COUNTY COUNCIL'S RESPONSE TO CONSULTATION ON THE FOLLOWING DEVELOPMENT PROPOSAL

Application No: 17/02534/OUT-2

Proposal: OUTLINE - The construction of a business park of up to 60,000 sq.m (GEA) of flexible Class B1(a) office / Class B1(b) research & development floorspace; parking for up to 2,000 cars; and associated highways, infrastructure and earthworks

Location: Land North Of Bicester Avenue, Garden Centre, Oxford Road, Bicester.

— Highway Boundary

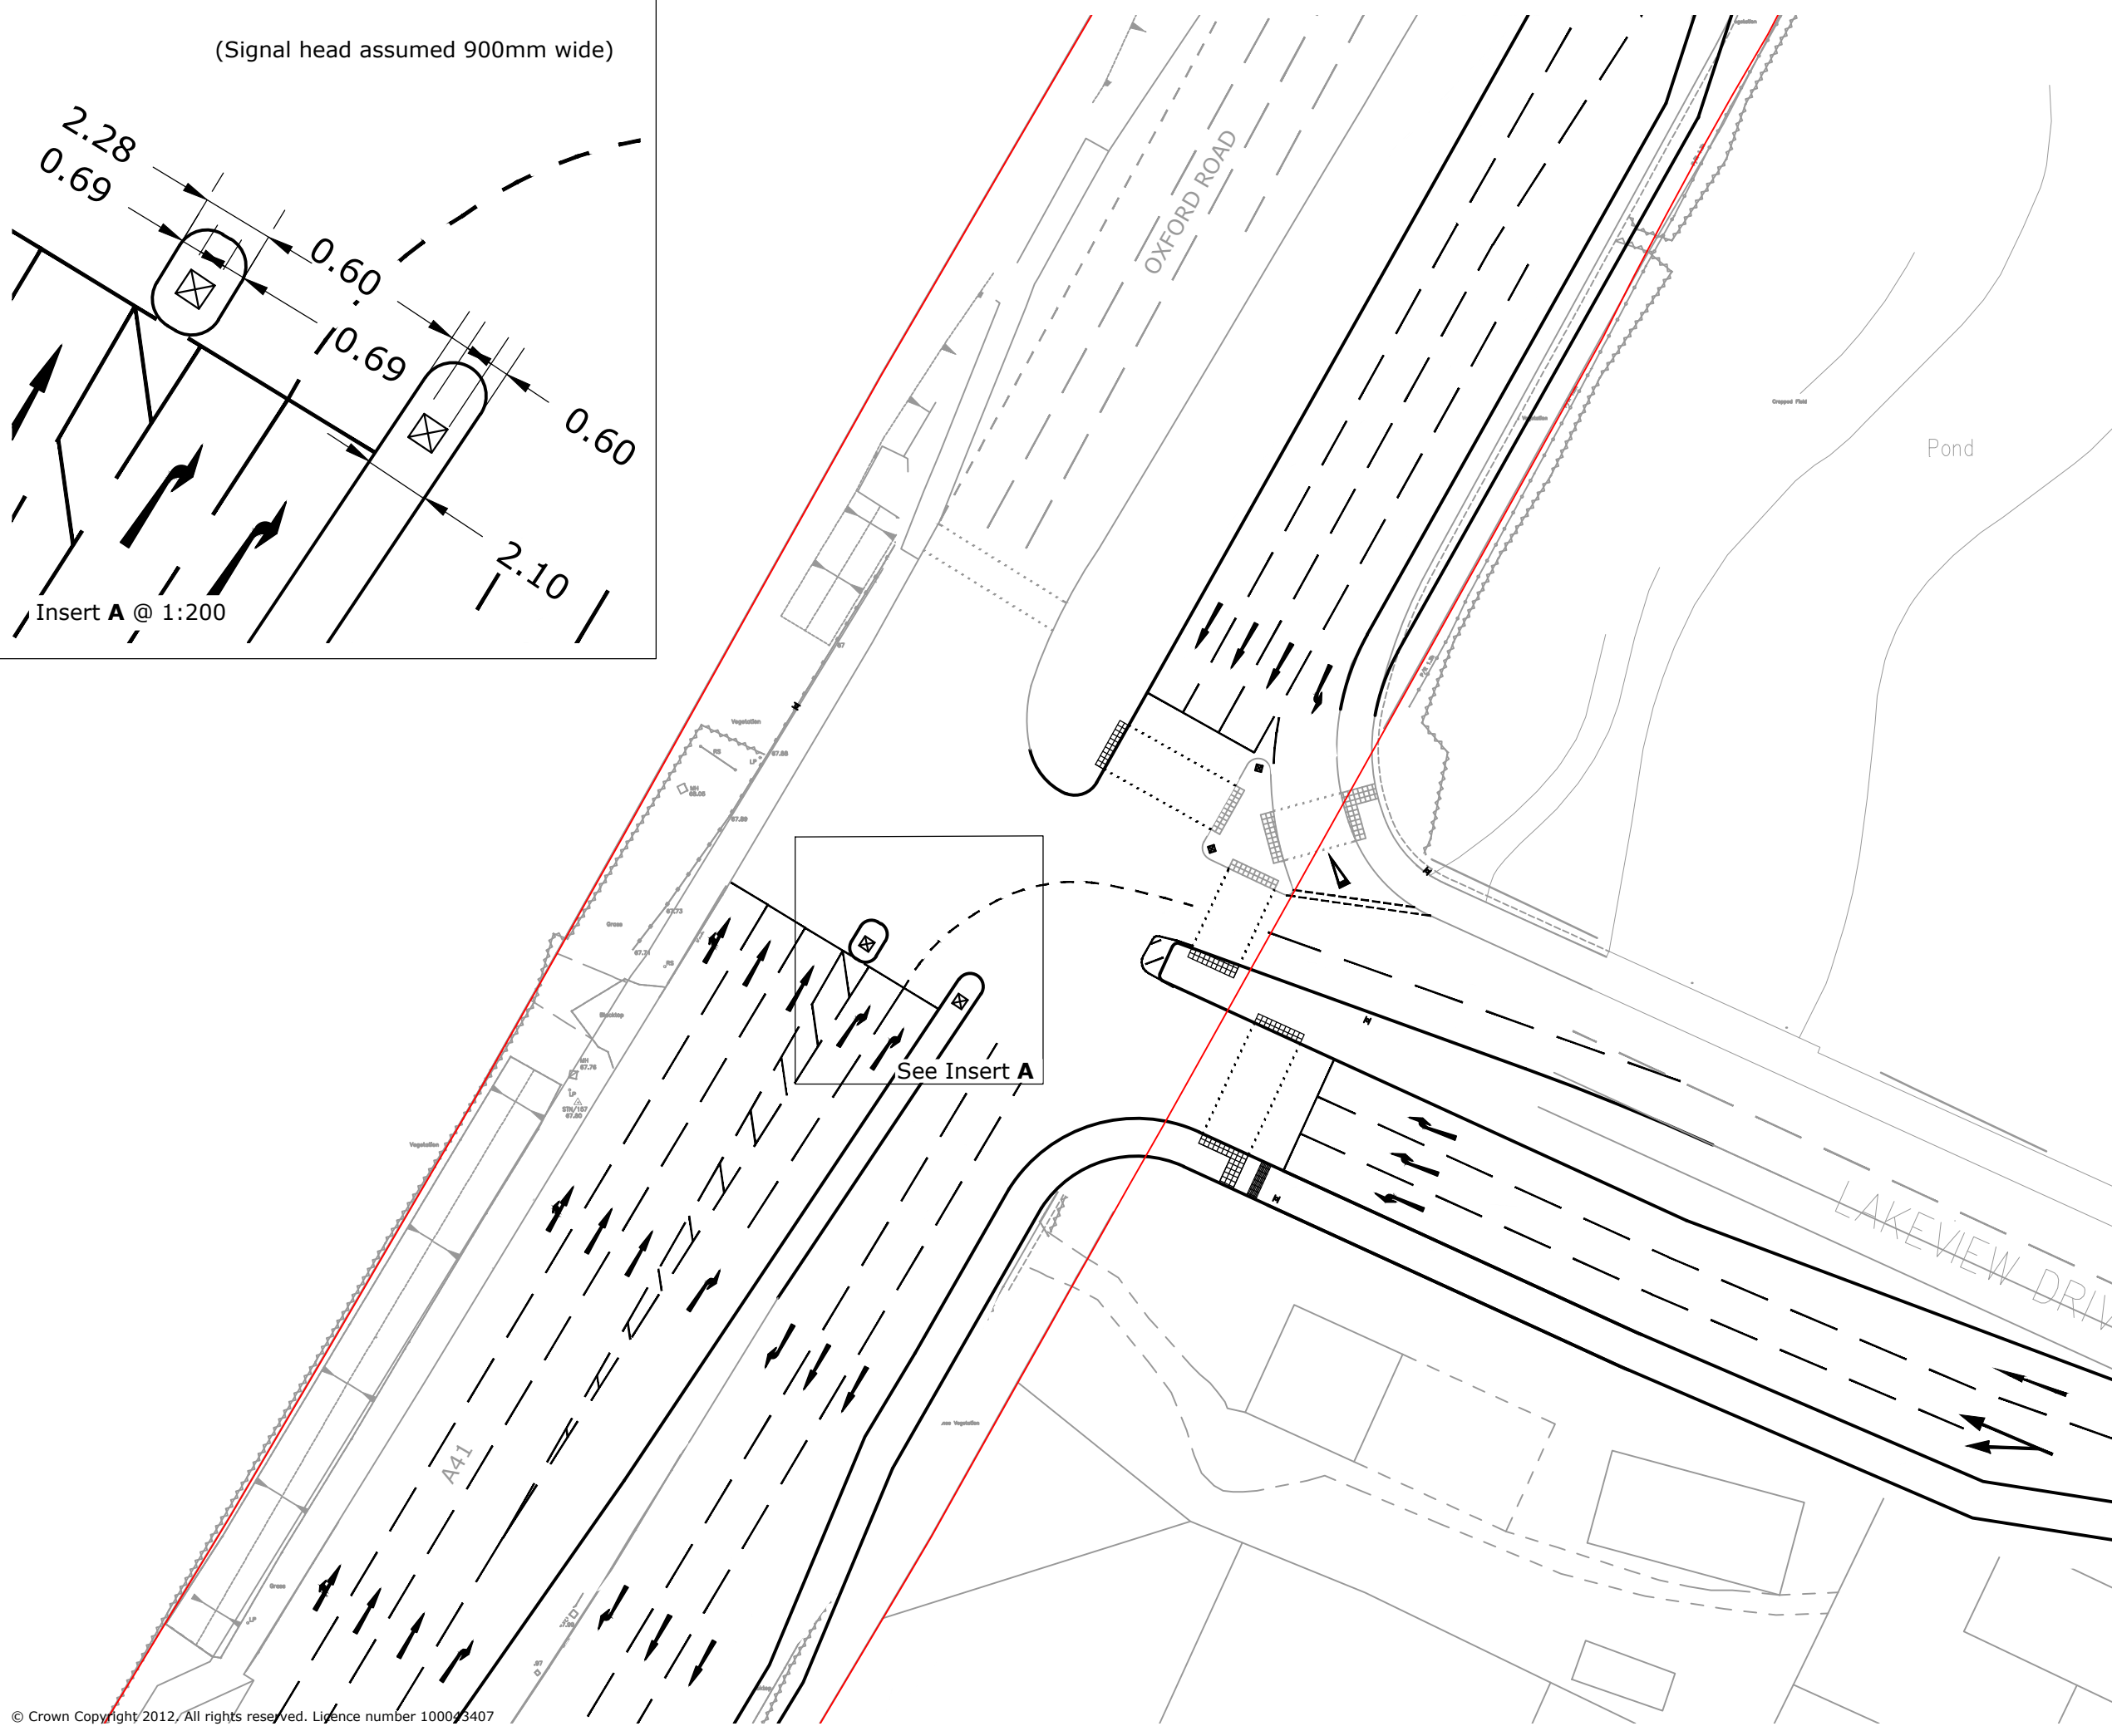
Table 6.3 is a summary of the junction modelling results with 60,000 sqm of office development including proposed mitigation. The 2026 with development and mitigation scenario predicts RFC values of 0.91 on the Kings End arm (AM peak) and 0.90 on Oxford Road (PM peak) which are both well over the theoretical operational thresholds. *Para 6.11* of the TA concludes that the junction shall be expected to operate within theoretical capacity to which I disagree, again pointing out that the LHA follows the accepted practice of treating RFC values over 0.85 as being above theoretical threshold for capacities at roundabouts.

To this extent and in consideration that conventional roundabout modelling was used in place of a mini roundabout I do not agree with *para. 6.12* in the TA that claims betterment on one entry yet operation on other arms is seen to deteriorate.

Analysis from the tables referenced above shows that without mitigation, Oxford Road/Lakeview Drive junction is predicted to deteriorate significantly. The Practical Reserve Capacity is shown to plunge into a more negative value indicating that the junction shall typically be suffering from traffic congestion, with queues of vehicles beginning to form. Degree of Saturation (DoS) values on certain arms particularly Oxford Road are observed to be significantly over the theoretical capacity.

Whereas the proposed mitigations appear to present a degree of improvement on the entire junction (as illustrated in *Table 6.6*), Oxford Road/Lakeview Drive junction is predicted to suffer more in the “Do-Something” scenario than the “Do-Nothing”. In the Do-Nothing scenario, the junction is forecast to operate with a DoS of 70.4% and 85.8% in the AM and PM peak hours respectively in 2026. With the development, including the proposed mitigation this rises to 92.9% and 97.7% in the AM and PM peaks respectively. It is without question that the development shall have a detrimental impact on the existing network which has not been adequately mitigated.

The proposed mitigations do not bring the junction operation to a level that LHA sees adequate. The TA suggests that a Degree of Saturation of up to 100% is acceptable, but the Highway Authority does not accept this, and maintains that the threshold of acceptability should be 90%.

I am very concerned about the predicted queues on certain arms of the junction. The modelling exercise (*Table 6.6*) shows queues on Lakeview Drive reaching 42 vehicles from the junction. Lakeview Drive's distance (90 metres) from the junction to the roundabout with Tesco should be borne in mind when looking at queues of 42 vehicles. Taking a conservative approach that a queueing vehicle takes up to 6 metres, this Lakeview Drive section would accommodate only 15 vehicles before traffic backs up to the Tesco roundabout, effectively stopping any further vehicles from egressing.

With vehicles unable to exit Tesco it is likely that traffic within the site would back up to the extent that vehicles would not be able to get in, with the risk that queueing traffic would back up onto the A41.

Although *para 6.25* of the TA highlights that Lakeview Drive is privately owned and therefore queueing would be accommodated off the public highway, this section of road is shared by Tesco and the consented McDonalds restaurant. It is my opinion that it would be in public's interest that movement of traffic on Lakeview Drive is not disrupted. Very substantial delays could also be detrimental to road safety as they may well lead to unsafe manoeuvres by impatient drivers.
